Application Ref:	3/2026/0006				Ribble Valley Borough Council <small>www.ribblevalley.gov.uk</small>
Date Inspected:	20/01/26	Site Notice:	20/01/26		
Officer:	LW				
DELEGATED ITEM FILE REPORT:					APPROVAL

Development Description:	Proposed single storey double garage to replace adjoining dilapidated workshop, coal store and timber garage. Conversion of existing garage into bedroom/ ensuite. Replacement of septic tank with sewage treatment plant.
Site Address/Location:	Monks Barton, Longsight Road, Langho, BB6 8AD.

7276 - P02C

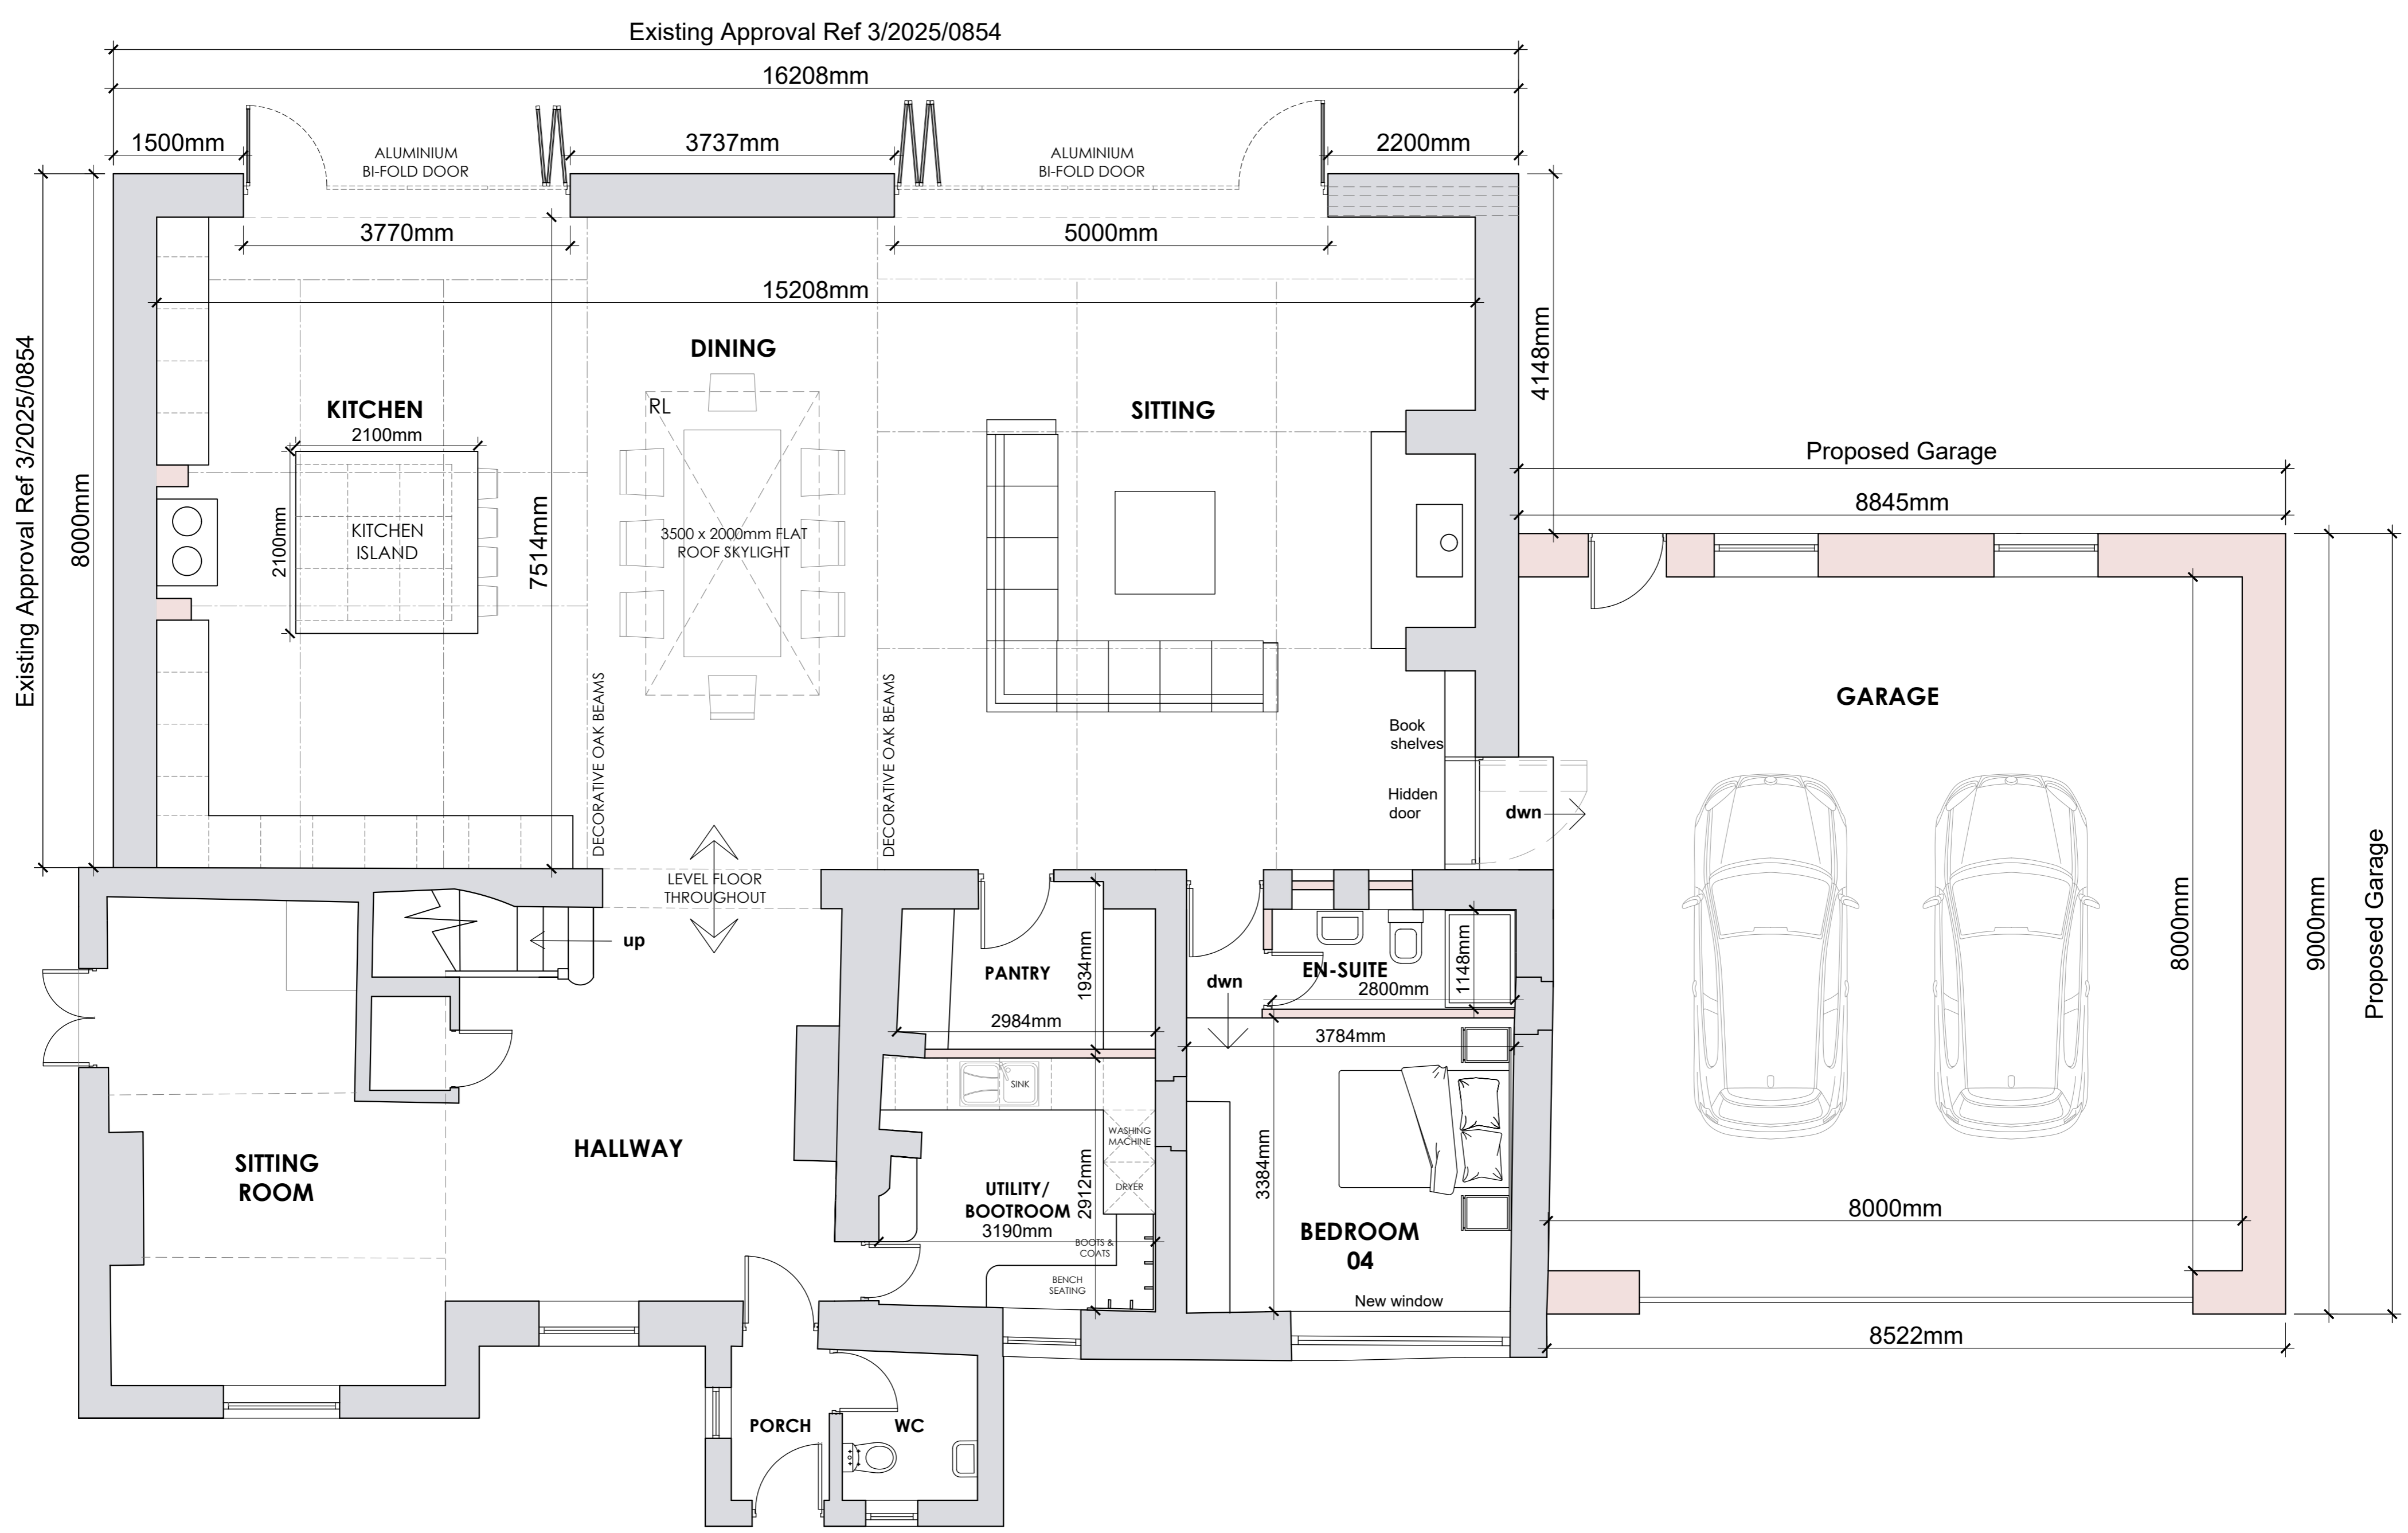
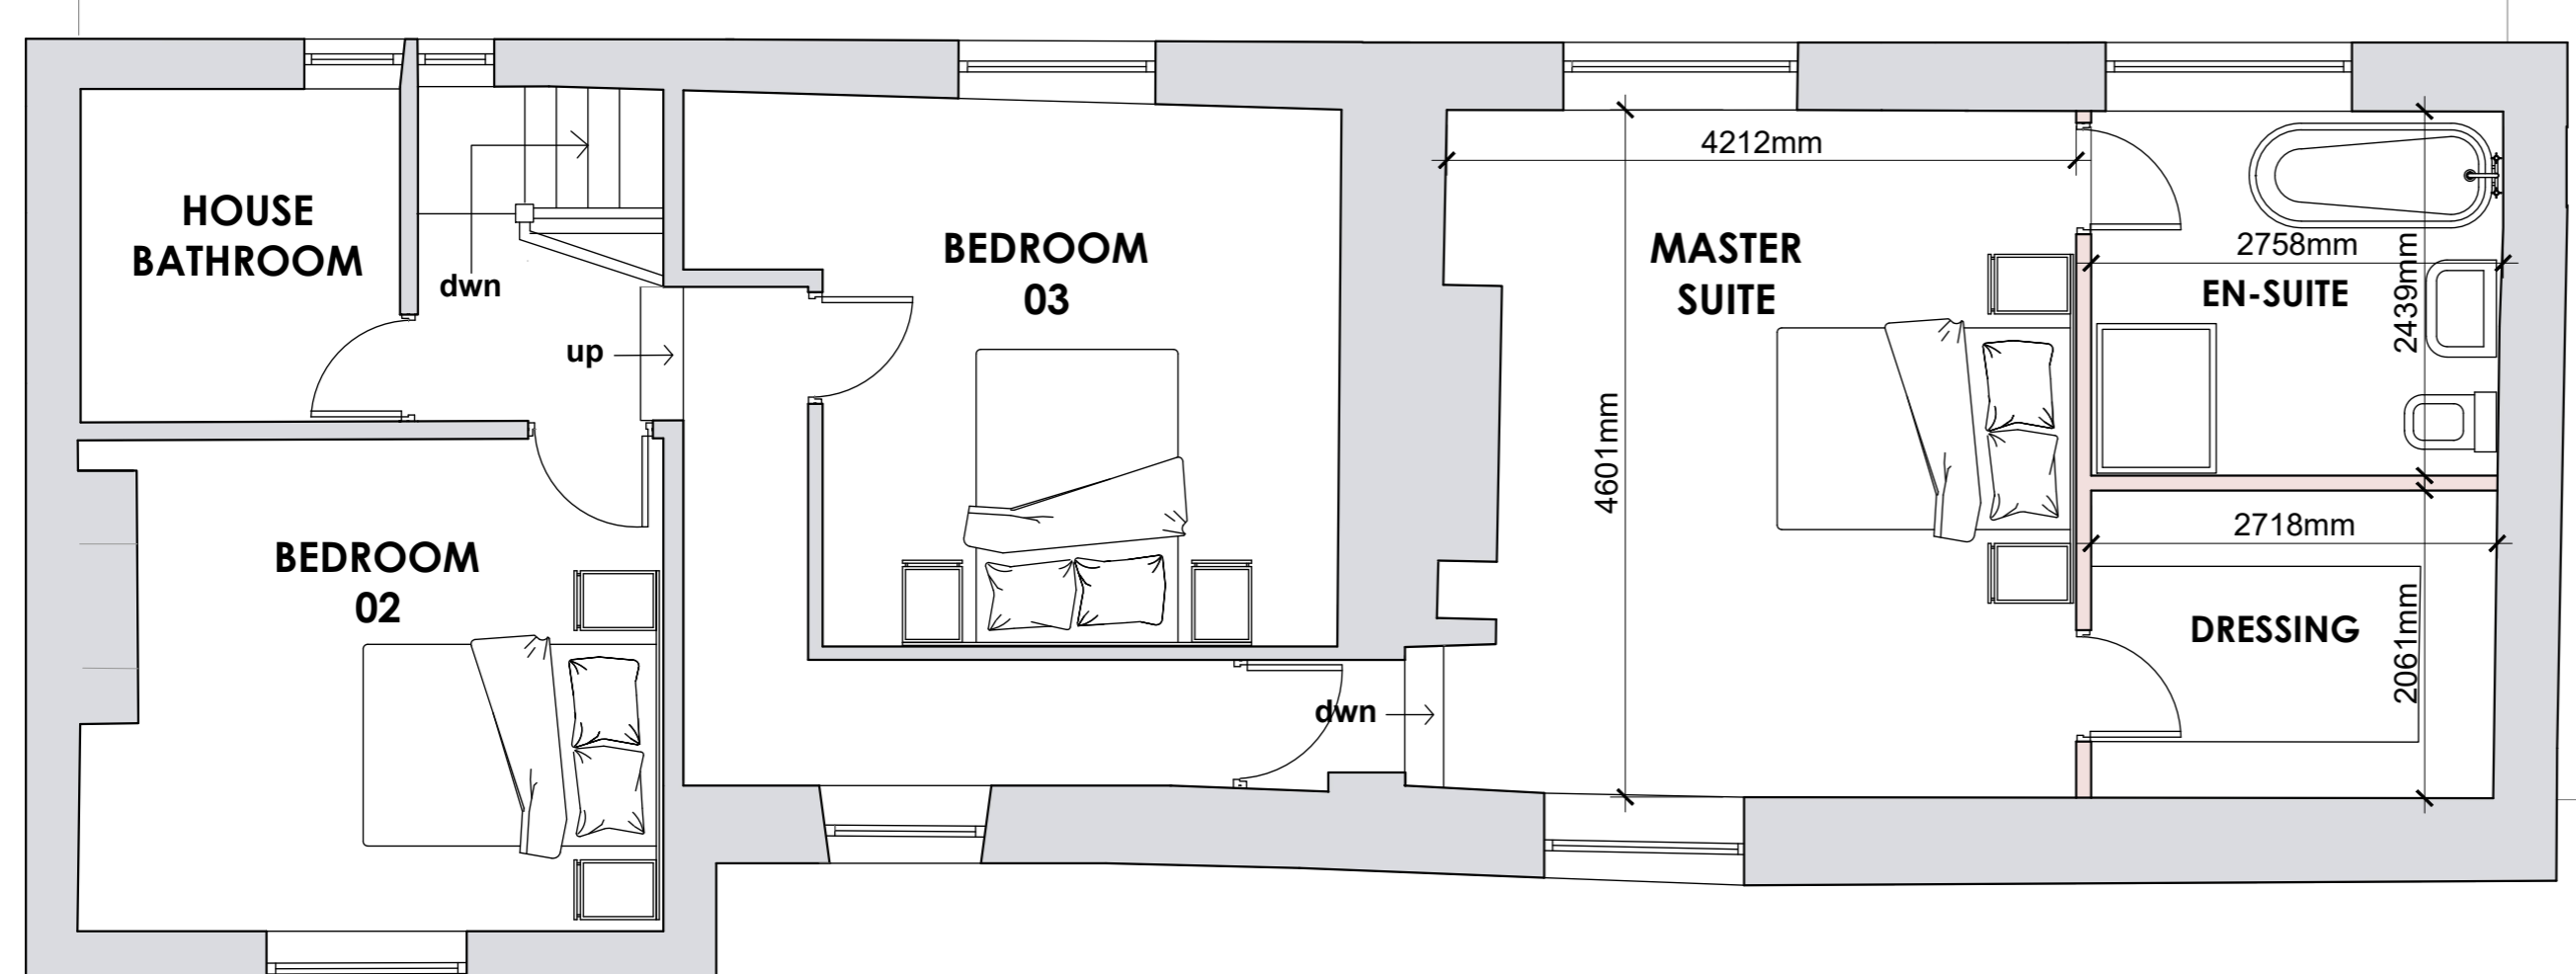
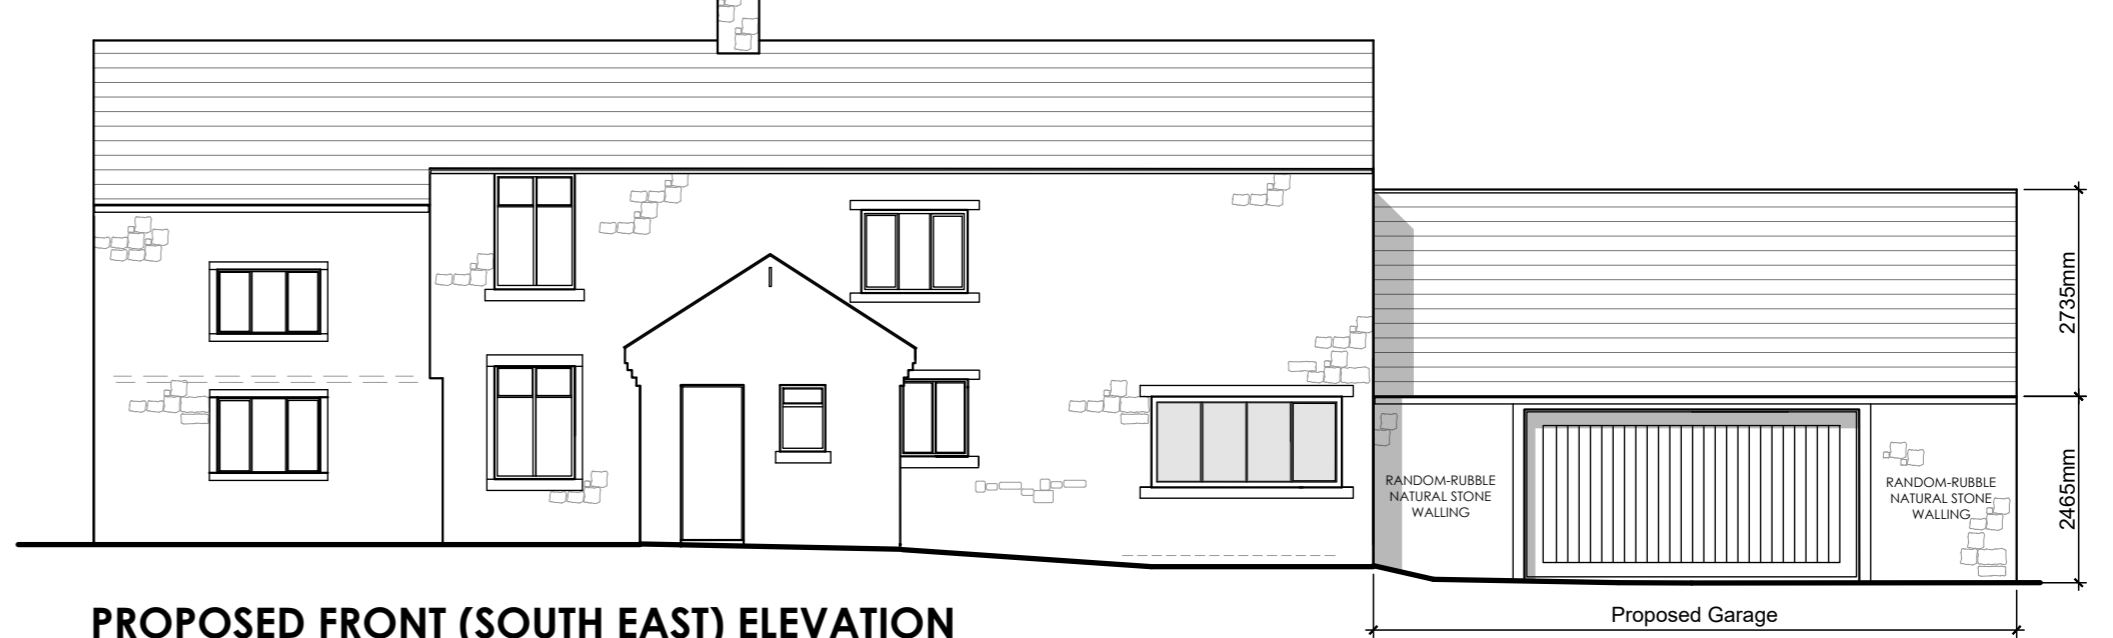
The proposed double garage originally submitted with the application comprised a footprint of 8.5m by 9m. However, this, together with the rear extension recently granted consent under prior approval application 3/2025/0854, was considered to result in a substantial cumulative increase in built form compared to the original property.

Following discussions with the Agent, the proposed garage has been reduced to a standard double garage size with a sideward projection of 6.52m and depth of 7m to accommodate a 6m-by-6m internal floorspace. A greater set back from the principal elevation of the dwellinghouse has also been incorporated. Whilst it is noted that the garage, together with the aforementioned rear extension, would still result in a substantial increase compared to the original built form of the property, when taking account of the size of the curtilage associated with the dwelling, it is not considered that the amended scheme would appear overly dominant or incongruous so as to warrant the refusal to grant planning consent for this reason alone. The proposed garage would be clearly set back from the principal elevation and down from the main ridgeline and the revised sideward projection of the addition would also not be
